Wansford Parish Council

Comments on D2 Submission by National Highways

TR010039-000523-7.3 Rev2 Transport Assessment

A47 Wansford to Sutton Dualling

Figure 7-13: VISSM Journey Time Routes

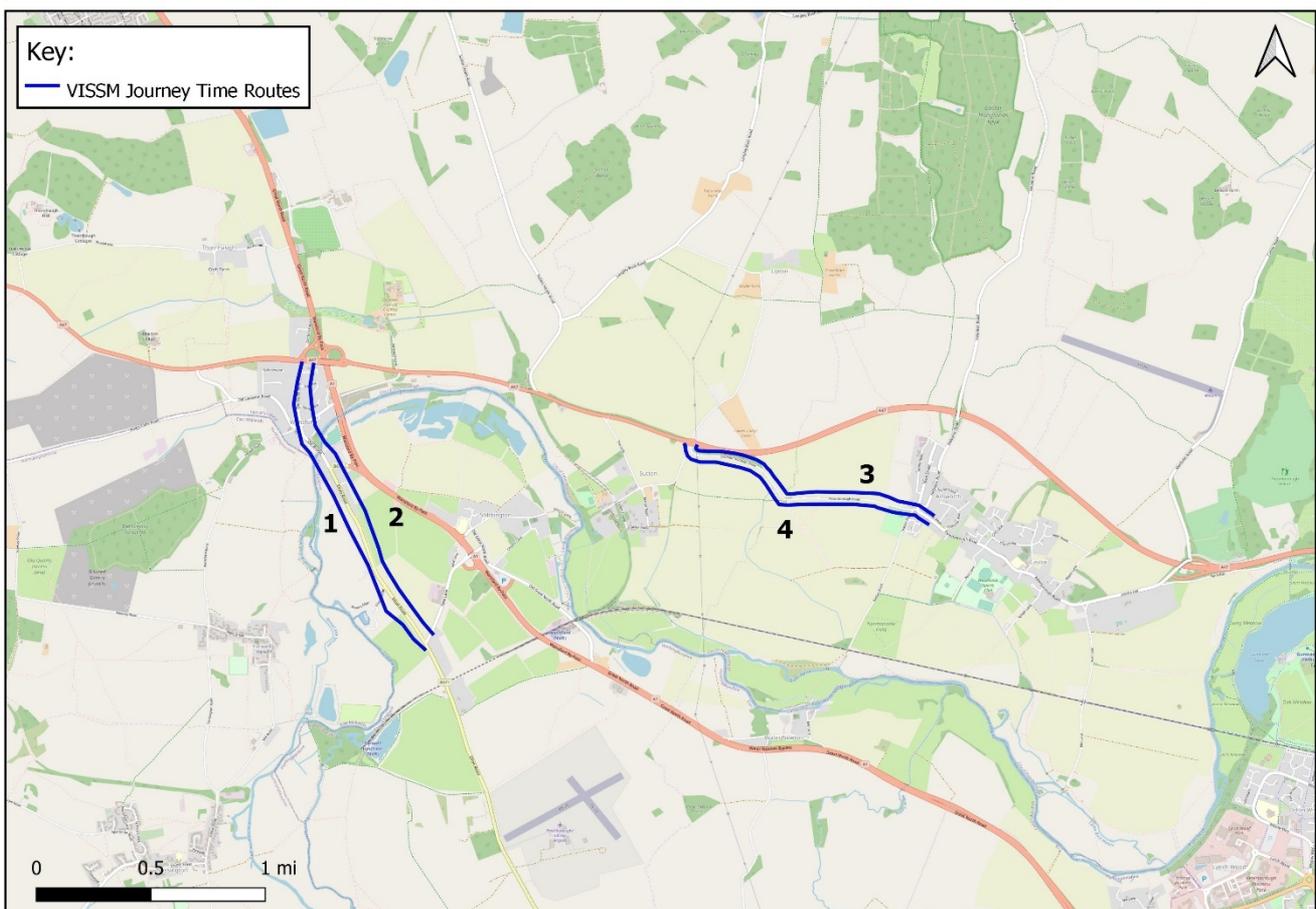
On a much more minor point, Table 7.2 describes a travel time of 4.4 minutes from Wansford Road to the western roundabout of 4.4 minutes. Figure 7.13 shows this journey as being from Elton to the roundabout, a distance of just over 4 miles. As the journey is on a twisty country road, including two stretches of 30 mph limits, the 20mph Wansford limit and the 120m long single track Wansford bridge, this journey time is completely implausible.
